Application by Highways England for A47 Wansford to Sutton Dualling

The Examining Authority's written questions and requests for information (ExQ1)

Issued on 16 December 2021

**NOTES**

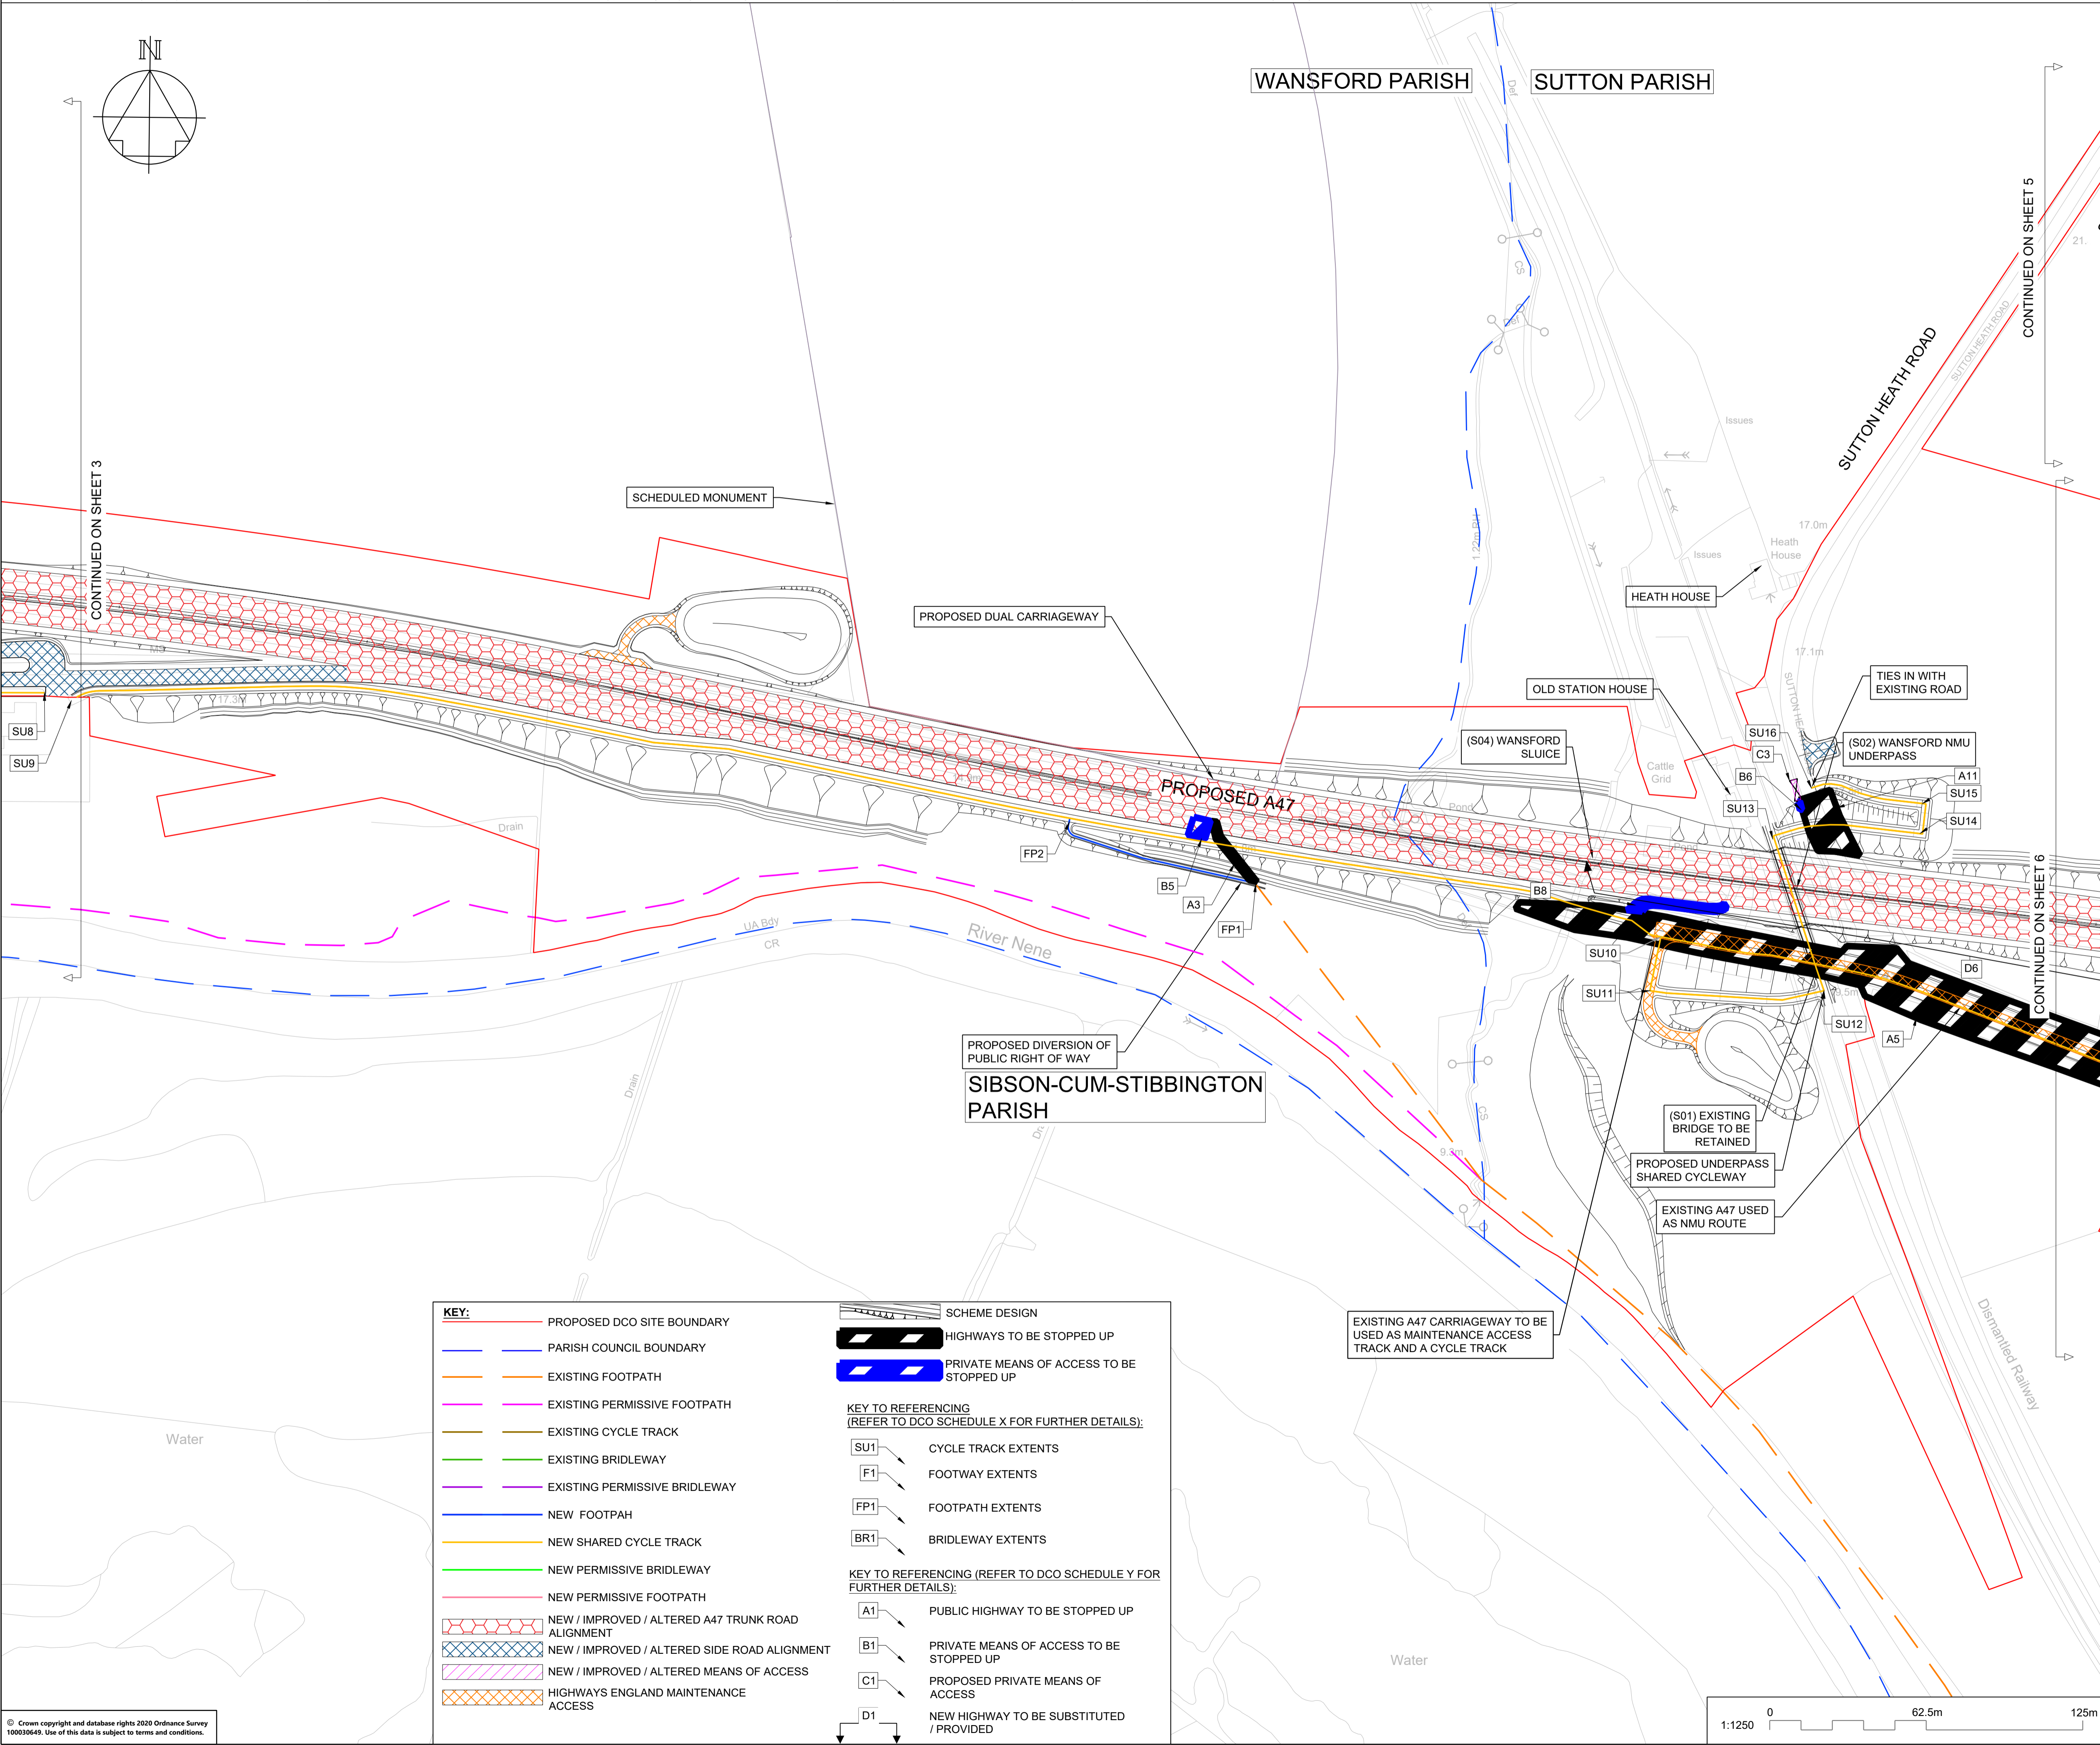
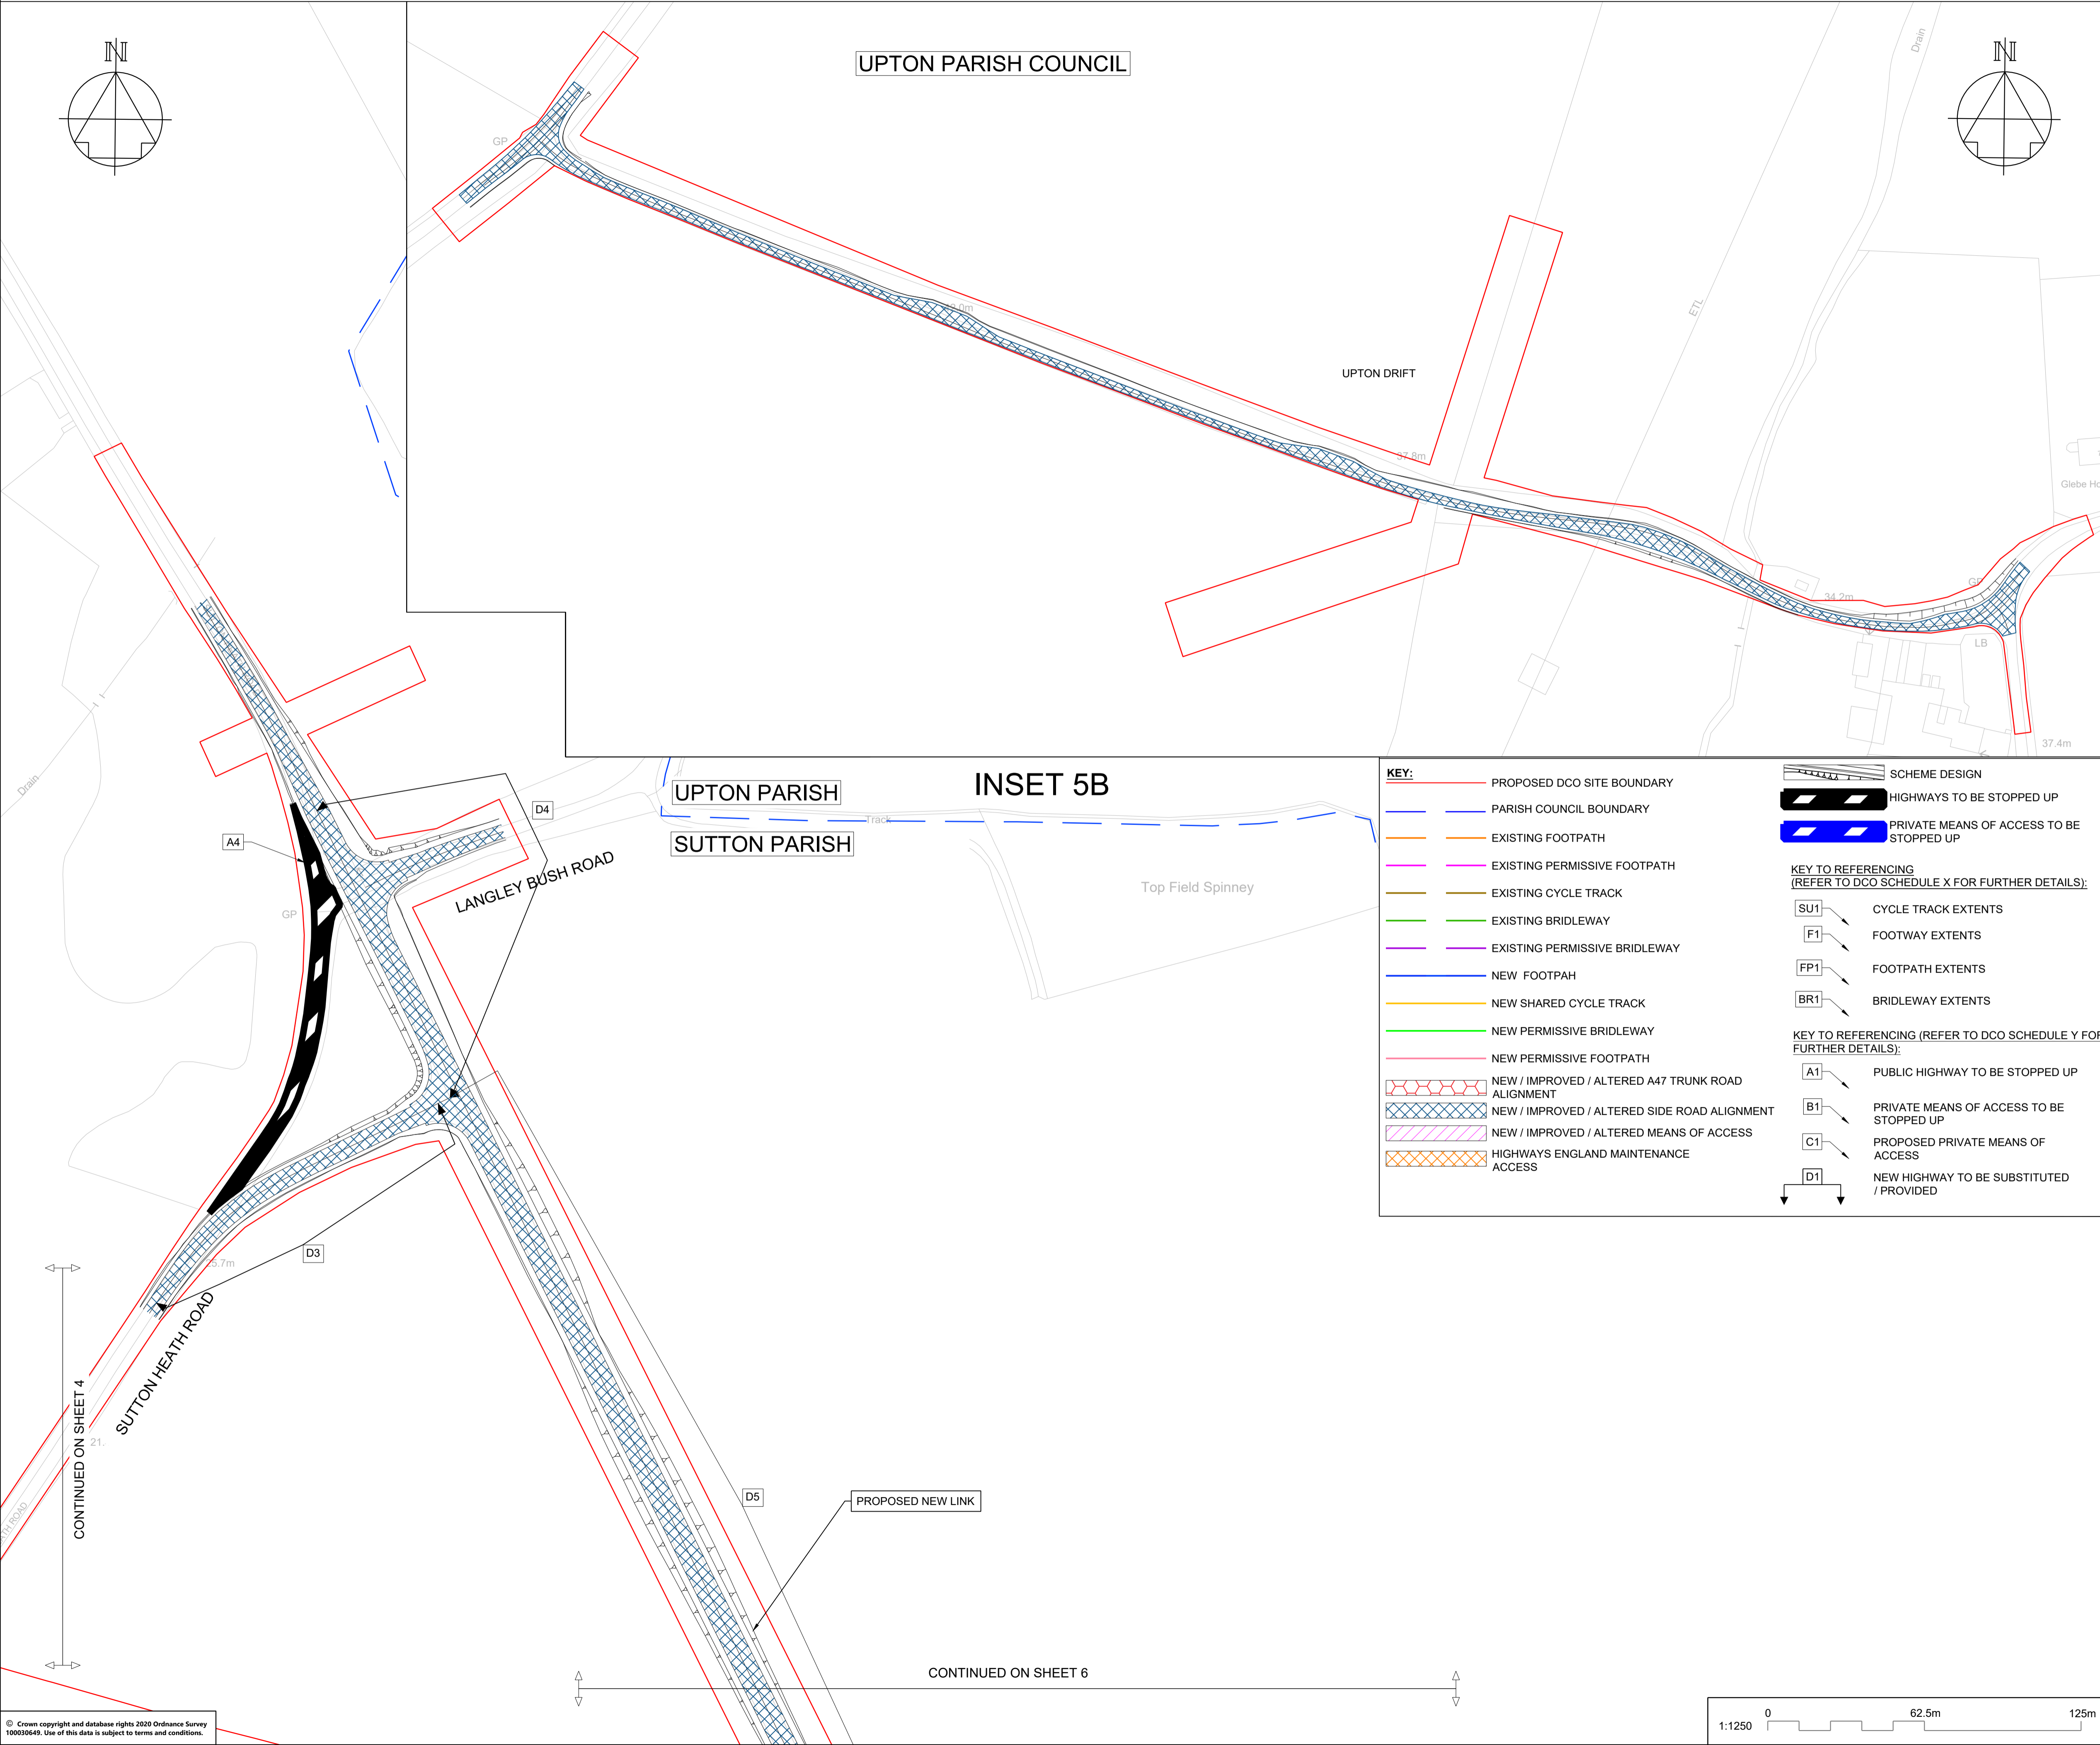
1.0.8.	The Applicant	Rights of Way and Access Plans a) Key has Schedule X and Y – please amend. b) Some drawings are titled “Rights of Way and Access Plans” and other “Public Rights of Way and Access Plans” – is there a reason for this or should/ can this please be made consistent?
